Current Zoning: R-3 (single family, residential)
Proposed Zoning: R-8MF(CD) (multi-family residential, conditional)

Approximately 38.18 acres located along the southwest side of Gibbon Road, east of Statesville Road, and south of Old Statesville Road.

The petition proposes to develop a residential community with up to 287 single family attached dwelling units together with accessory uses.

PLANNING STAFF REVIEW

REZONING PLAN
RZ.01

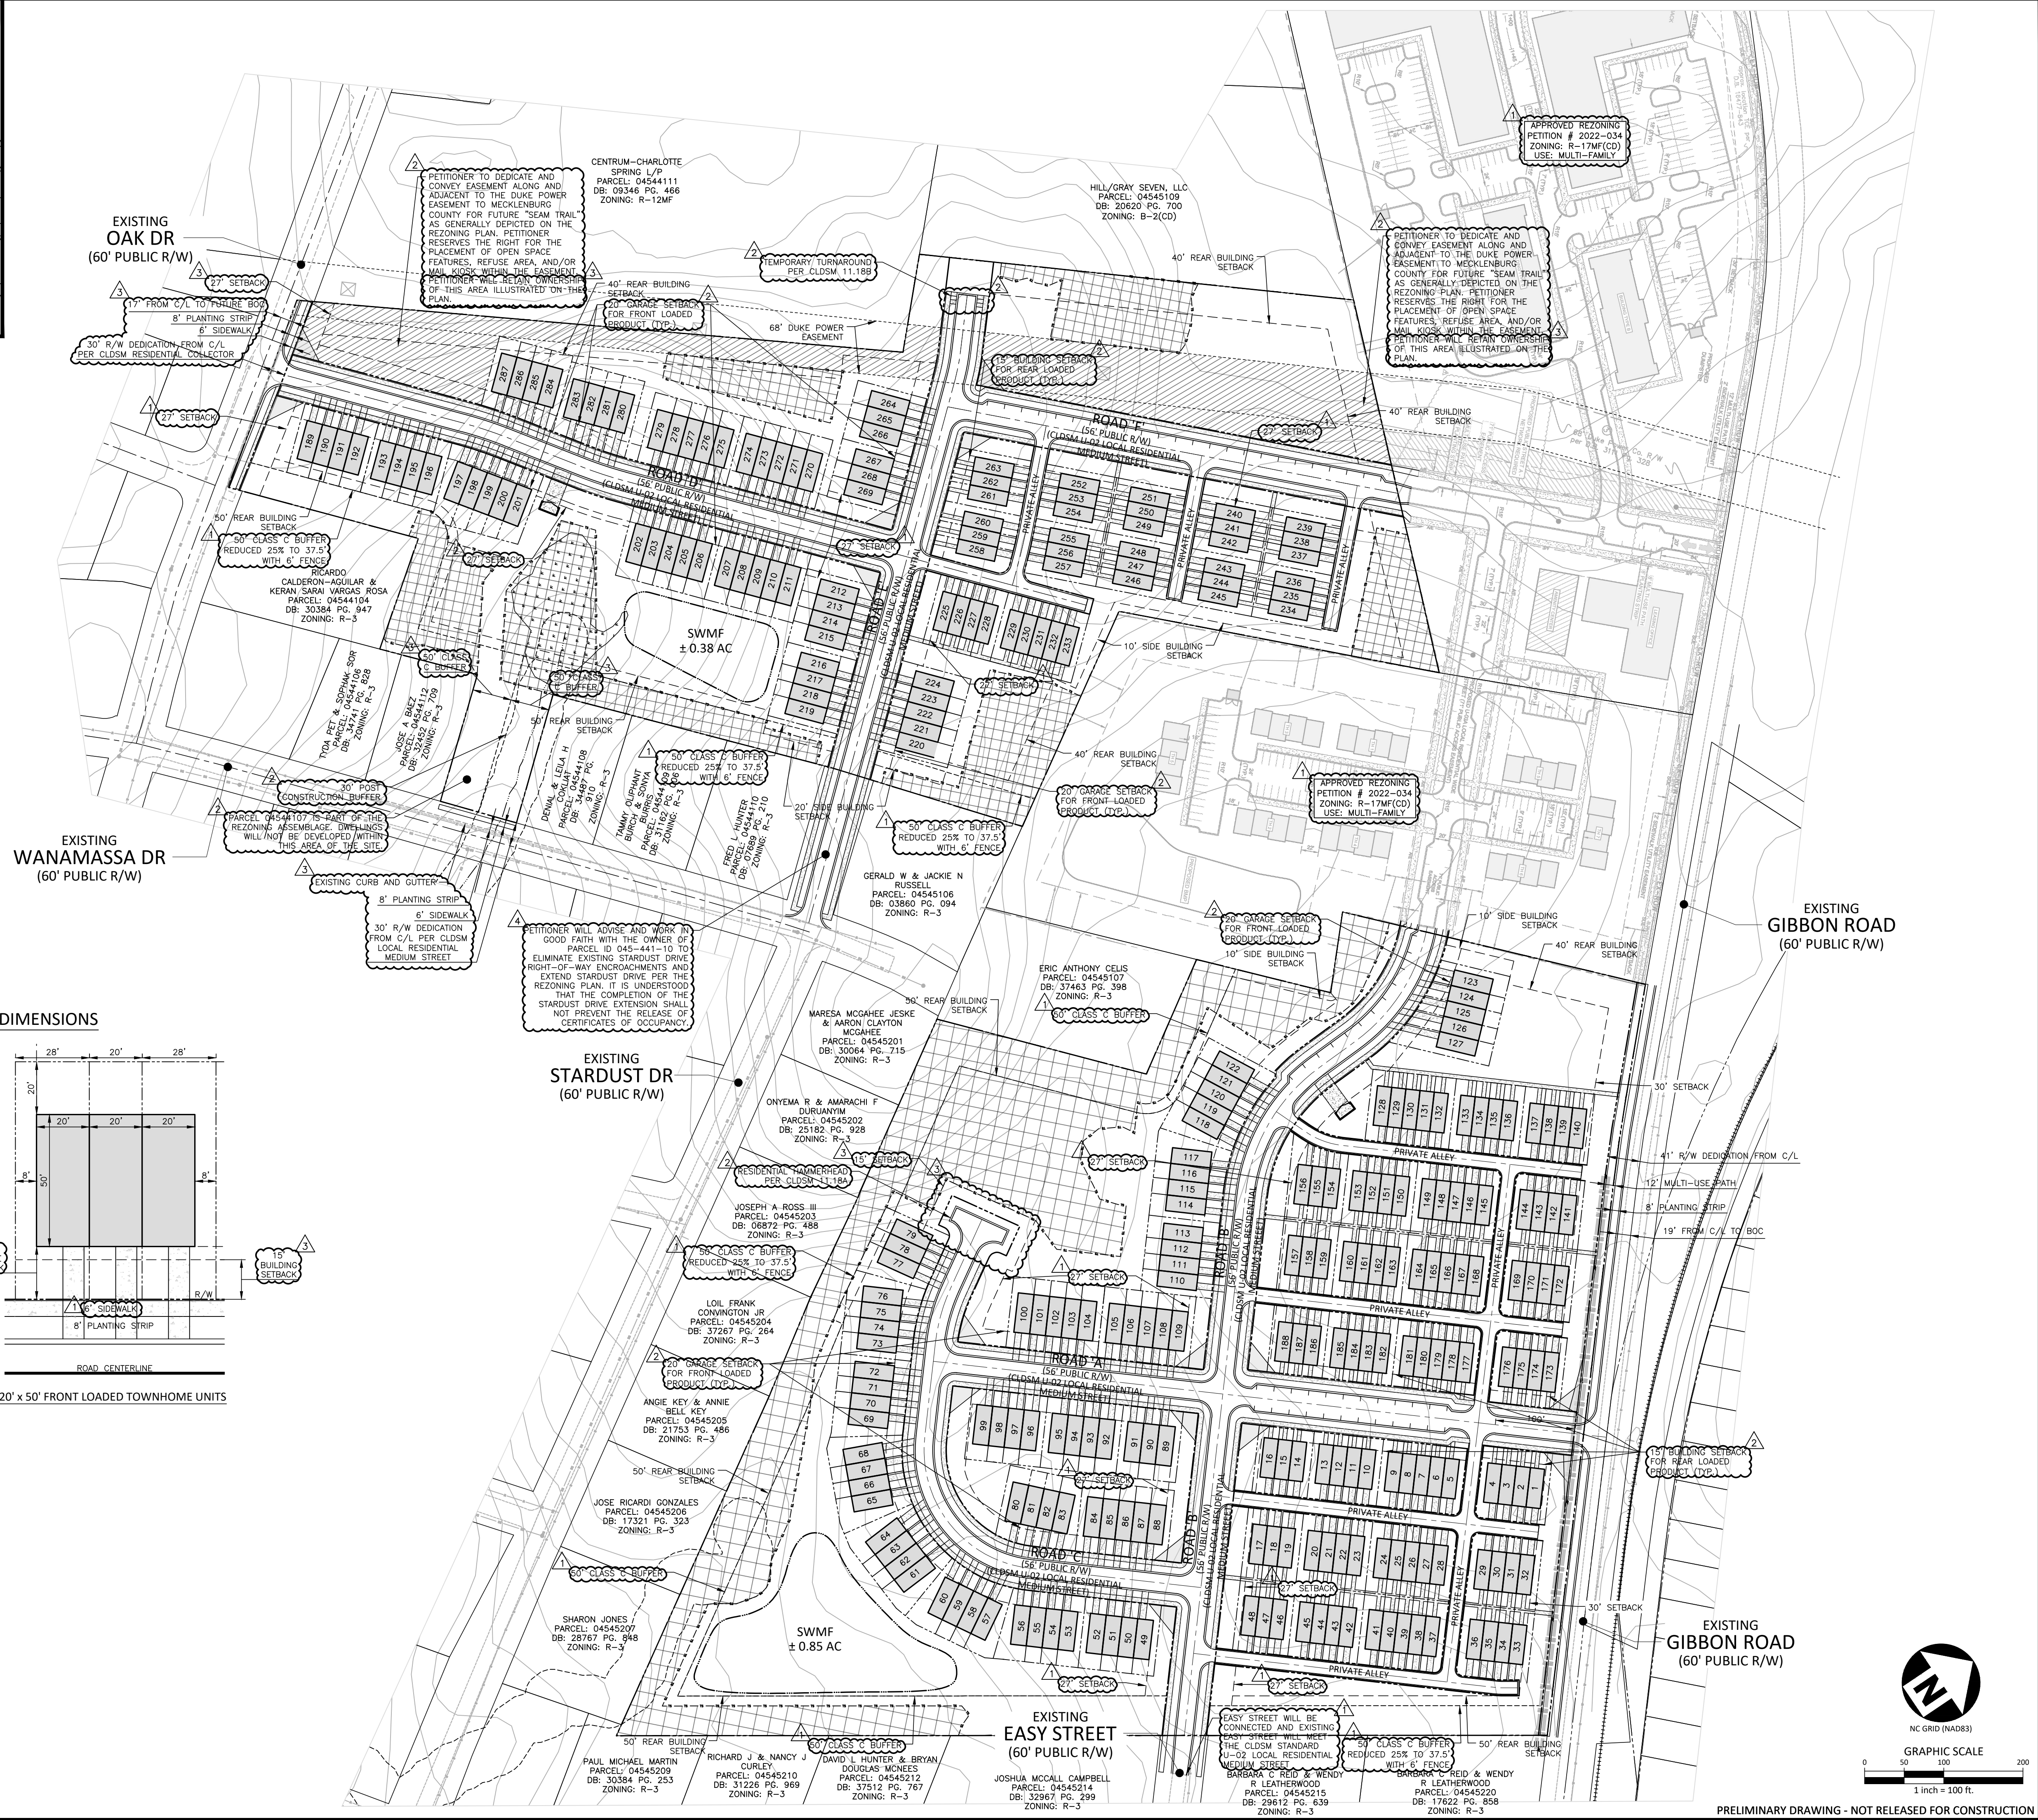
1. ~~Oak Drive: Curb and gutter shall be placed along the entire site's frontage. Label and dimension the proposed curb line from the exiting centerline of the road.~~ Addressed

2. ~~Wanamassa Drive: Curb and gutter shall be placed along the entire site's frontage. Label and dimension the proposed curb line from the exiting centerline of the road.~~ Addressed

3. ~~Revise conditional note(s) to commit to dedicate 28 feet of right-of-way from the road centerline along Wanamassa Drive in coordination per CLDSM Local Residential Medium Street and 30 feet of right-of-way from the road centerline along Oak Drive in coordination per CLDSM Residential Collector. The site plan shall label and dimension the right-of-way from the road centerline.~~ Addressed

4. ~~Revise site plan and conditional note(s) to commit to construct an 8-foot planting strip and 6-foot sidewalk along the site frontages on Oak Drive and Wanamassa Drive. The site plan shall label and dimension both items from the back of curb and gutter and road centerline.~~ Addressed

5. ~~Revise site plan and conditional note(s) by removing callout from site plan and conditional note 3.k.~~ Addressed
